Schedule of Additional Minor modifications (refer to numbered revision clouds on the drawings)

ar-1205 **B06**

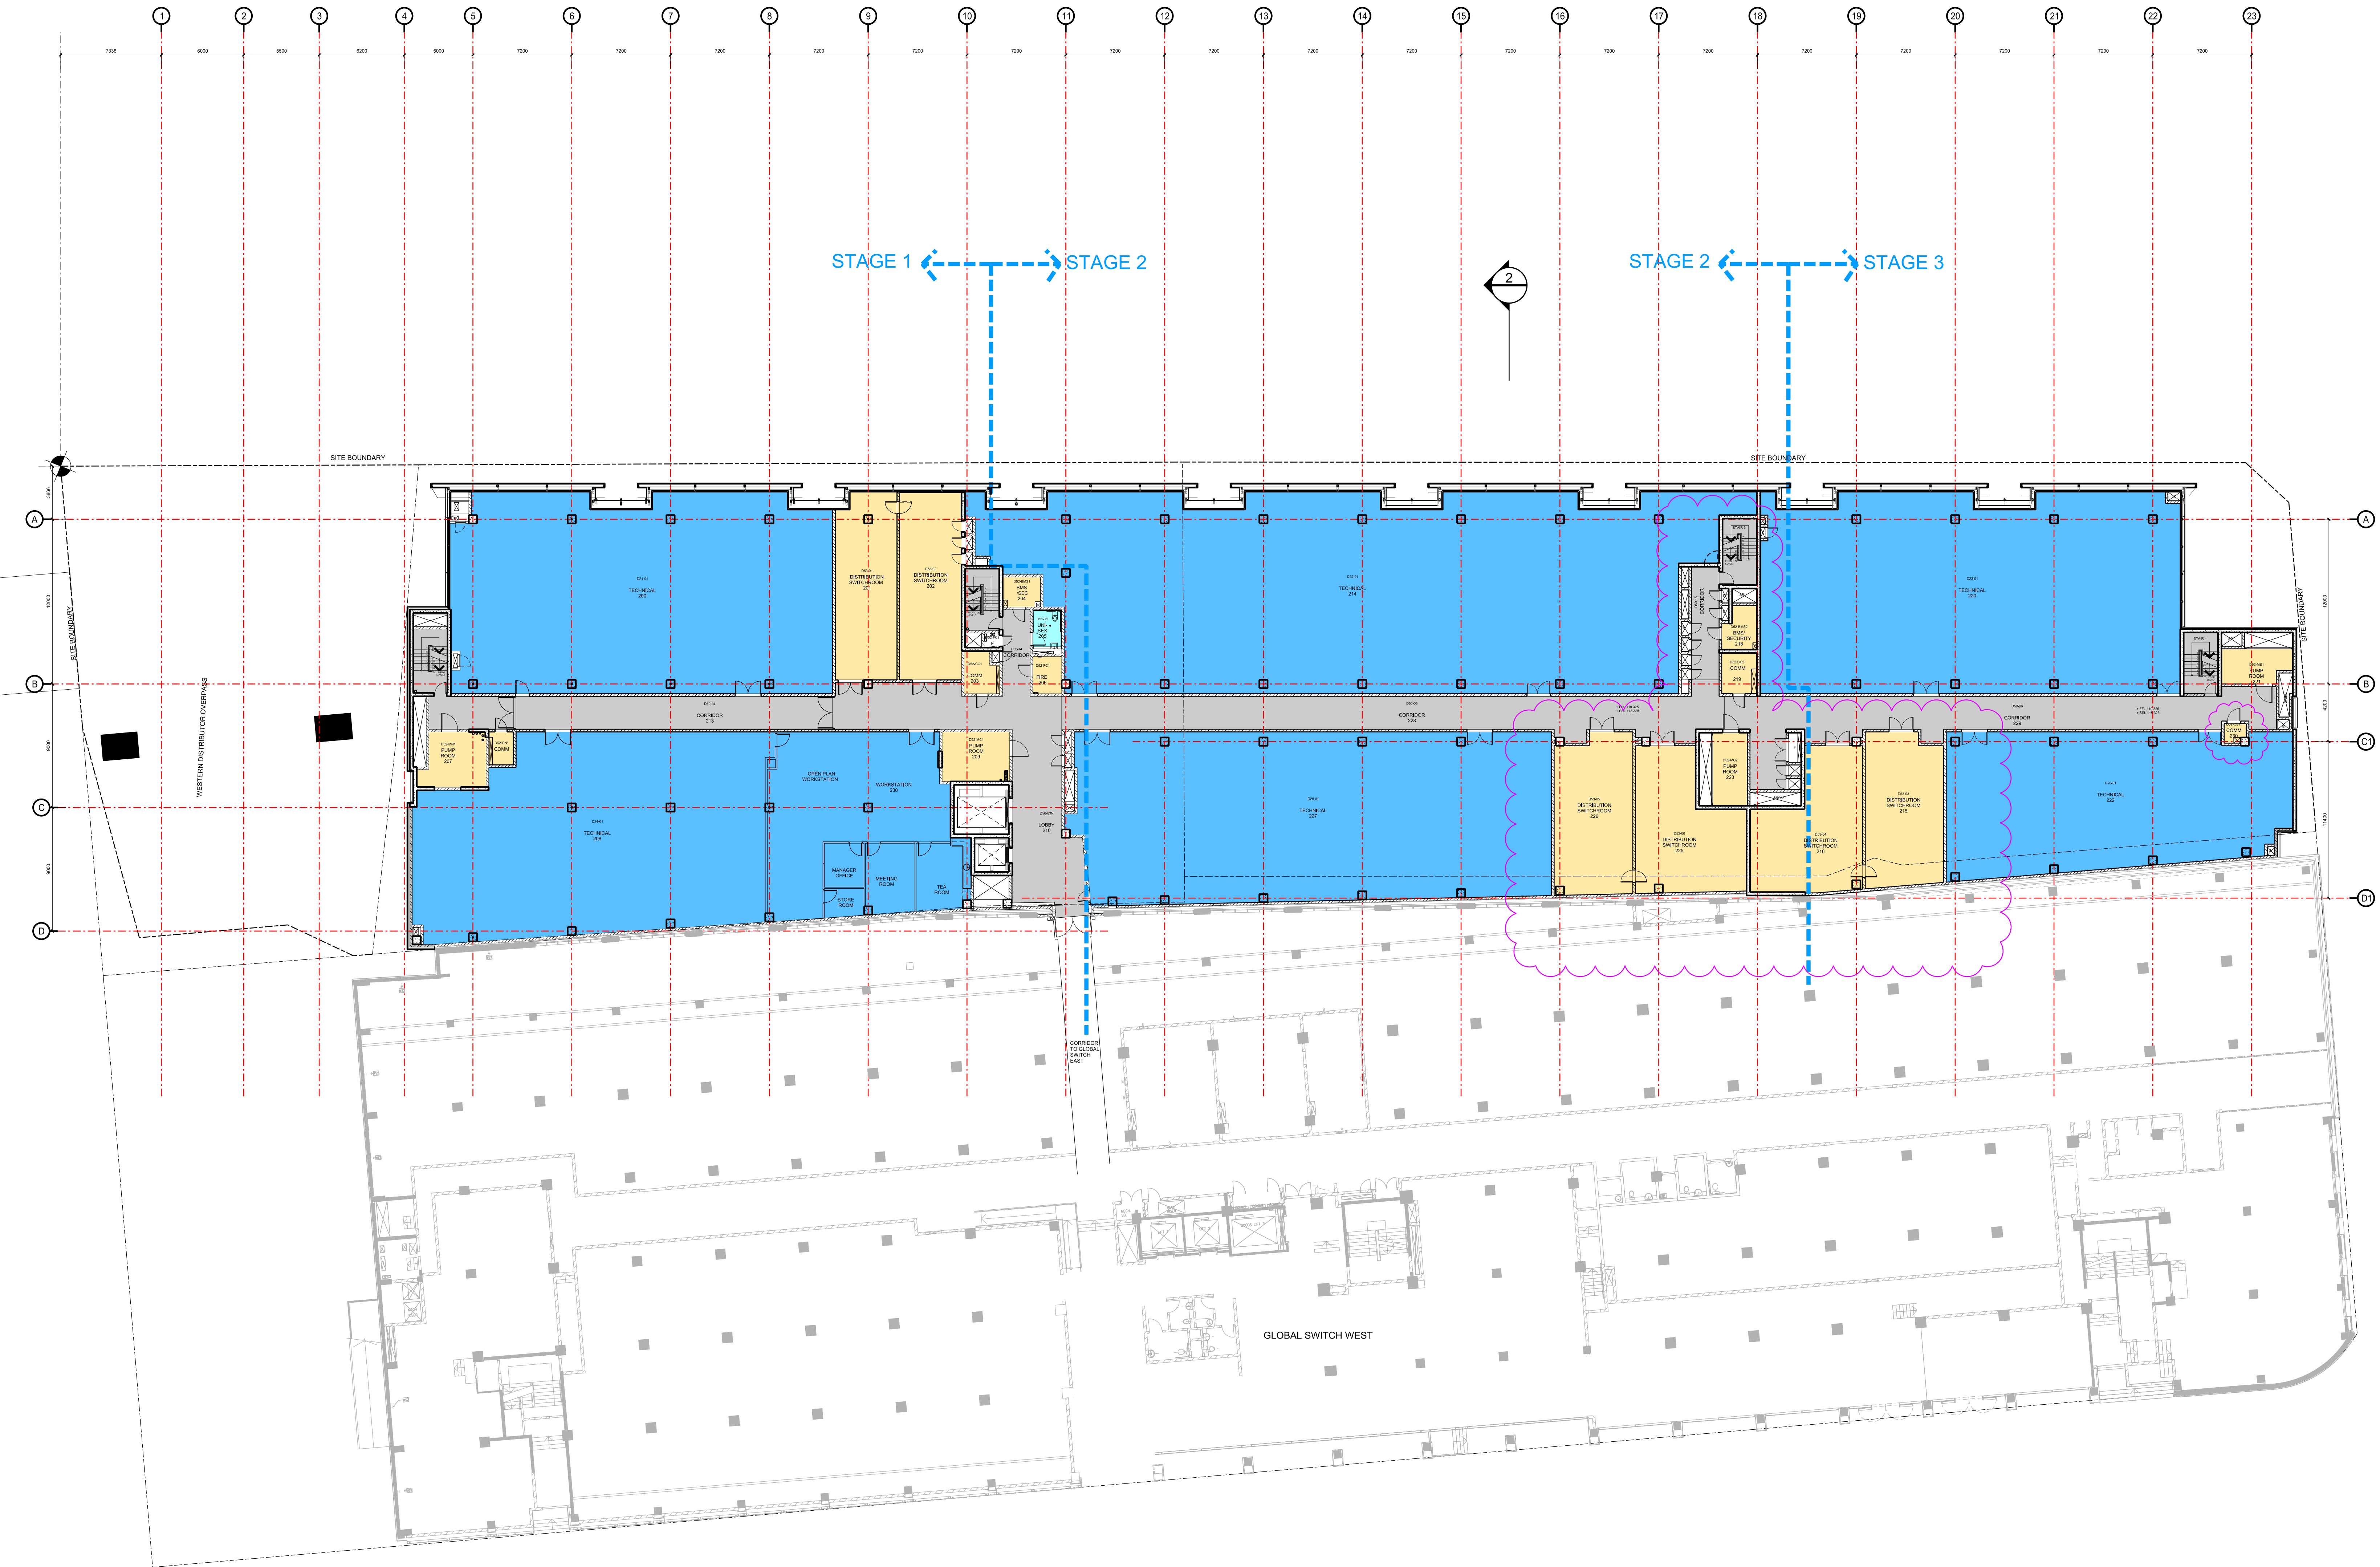
Drawing number	Revision cloud number	Floor level	Description of amendment
ar--1203	1	Ground	Stage 1 BMS/Security room relocated and area added to Meet Me Room
	2	Ground	Pit room within the Stage 1 Meet Me Room deleted as not required.
	3	Ground	Fire Room not longer needs to be increased in size in Stage 2
	4	Ground	Stage 1 BMS/Security room relocated to the end of Lift lobby
	5	Ground	Proposed Stage 3 Meet Me Room relocated to Stage 2 area between grids 16 and 17 (already covered in the submission).
ar--1204	6	First	Stage 1 BMS/Security room relocated from Lift lobby
	7	First	Stage 1 BMS/Security cupboard in lift lobby relocated (refer to item 6)
	8	First	Extended area of cloud indicating relocation of switch rooms & technical area already described in the current planning modification submission & already included in revised area calculations
ar--1205	9	Second	Stage 1 BMS room relocated
	10	Second	Riser duct deleted as no longer required.

11	Second	Relocated position for Stage 1 BMS room.
	12	Second	Stage 1 BMS cupboard in lift lobby deleted.
	13	Second	Extended area of cloud indicating relocation of switch rooms & technical area already described in the current planning modification submission & already included in revised area calculations
ar--1206	14	Third	Riser duct deleted as no longer required.
	15	Third	Services cupboards deleted as no longer required.
	16	Third	Extended area of cloud indicating relocation of switch rooms & technical area already described in the current planning modification submission & already included in area revised calculations.
ar--1207	17	Fourth	Riser duct and air-conditioning plant room deleted as no longer required.
ar--1208	18	Fifth	Riser duct deleted as no longer required.
	19	Fifth	Change in size of UPS switch rooms in Stage 3 area
	20	Fifth	Air intake plenum in Stage 3 area extended
ar--1209	21	Sixth	Riser duct added.
